Subdivision Comments

From: Holly Erdman, Environmental Health Specialist II

RE: SP-22-00001 Morazz Estates

SHEET 1 OF 2

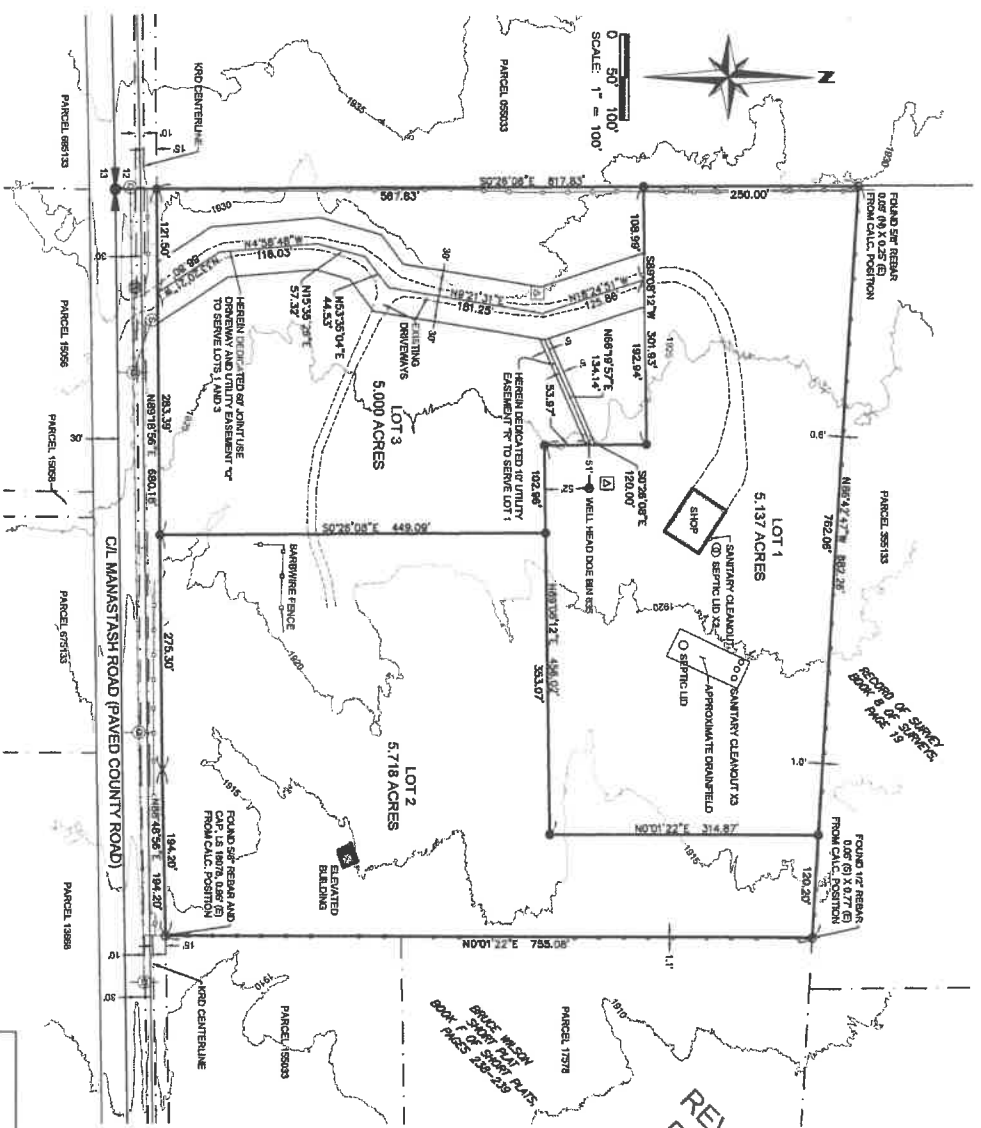
Soil logs must be done on the proposed lots 2 and 3.

The application states individual or shared wells will be used. Well logs and water rights must be provided for lots 2 and 3. If a shared well is used, a signed and recorded shared water user's agreement must be provided.
